From: Gedney, David
Sent: 31 March 2015 16:17
To: _planningadvice
Subject: FW: Applications H13-0212-15 and H13-0213-15 - Fascia signs, pallisade boundary fencing, etc, Naylors Farm, Roman Bank, Moulton Seas End
Attachments: Naylor Farms visual sign option B proof.pdf; 18114-150331.zip

Please scan email (not attachments) on file H13-0213-15 – 6SUP

| DRG No. 18114/43 | Rev<br>- |

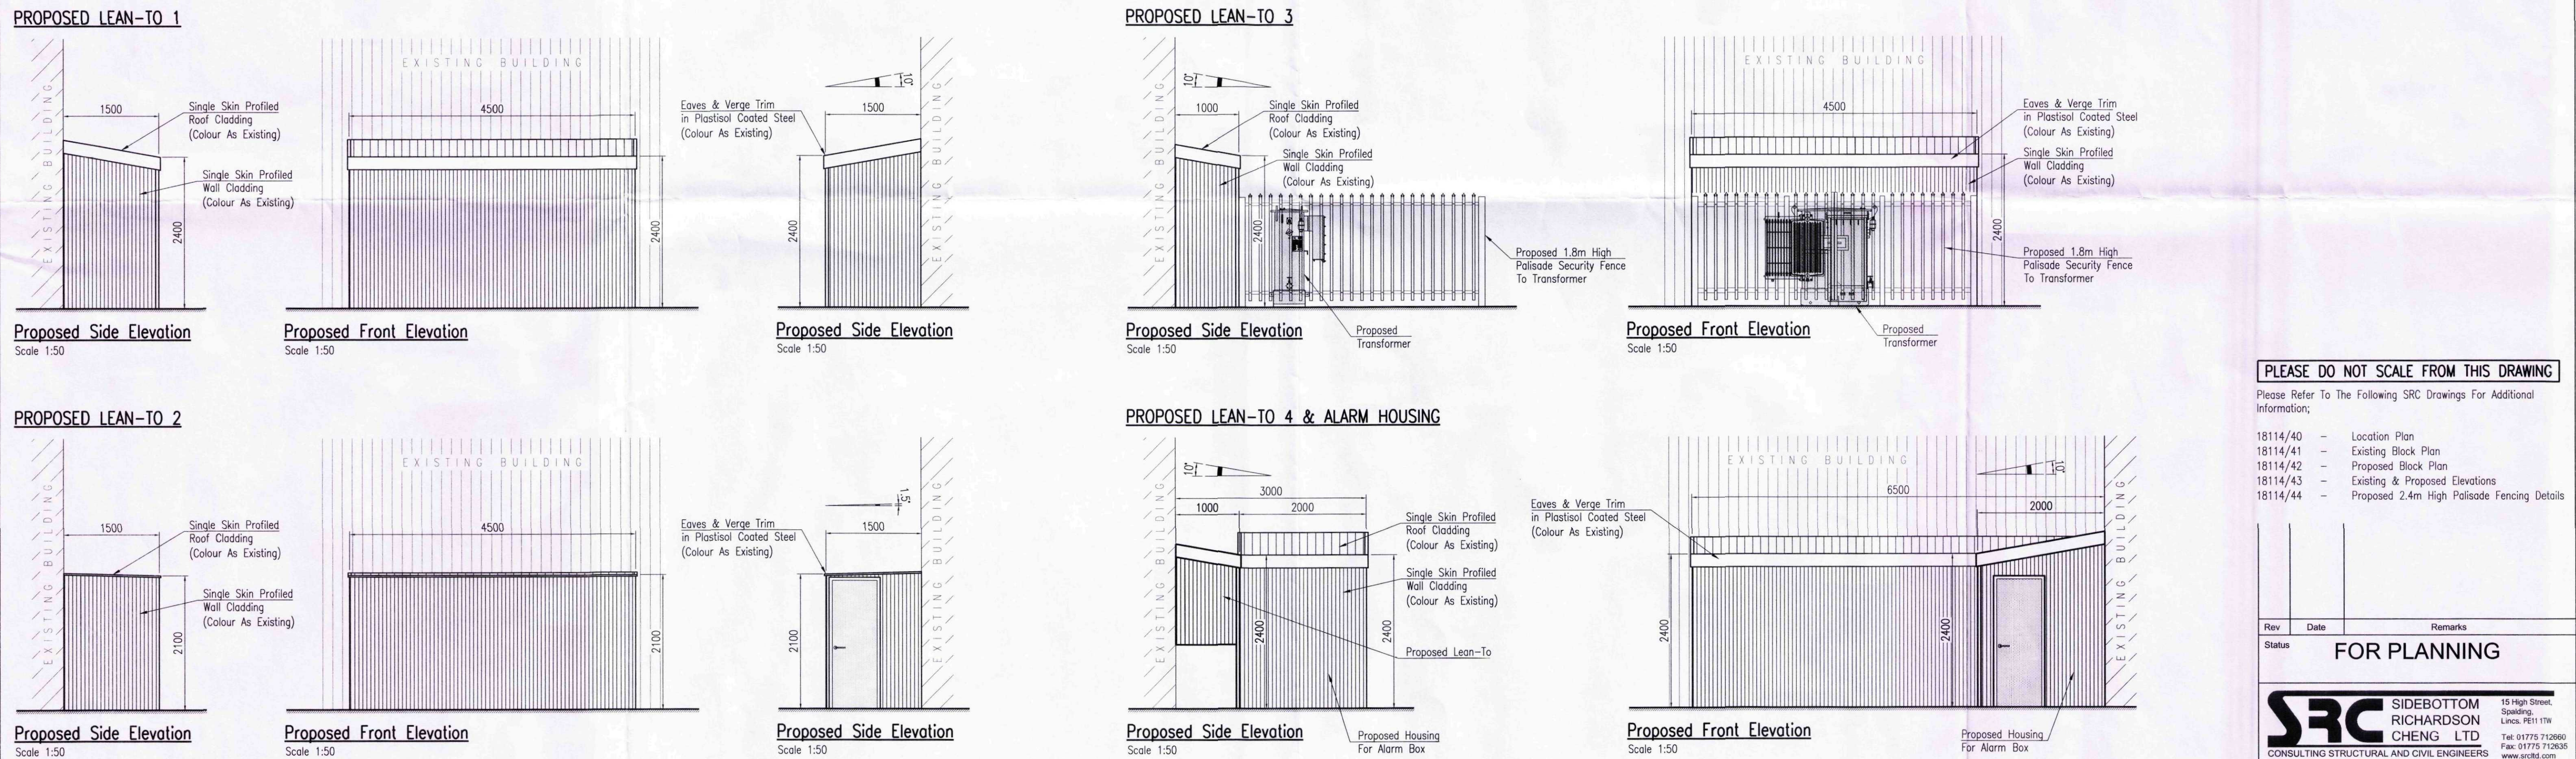
Pallisade fencing – The application indicates that the fencing is 2.4m in height. However, on site it varies in height between approximately 2.3m and 2.6m due to varying ground levels. The description will therefore be revised to reflect this unless you indicate otherwise.

The palisade fence that has been installed is a 2.4m high fence, however due to the ground levels the fence was needed to be stepped in 2 locations. This has been incorporated into our elevations drawing ref '18114-43', which clearly identifies the two 300mm steps in the fence and therefore as you have stated will vary in height between 2.4m and 2.7m approximately.
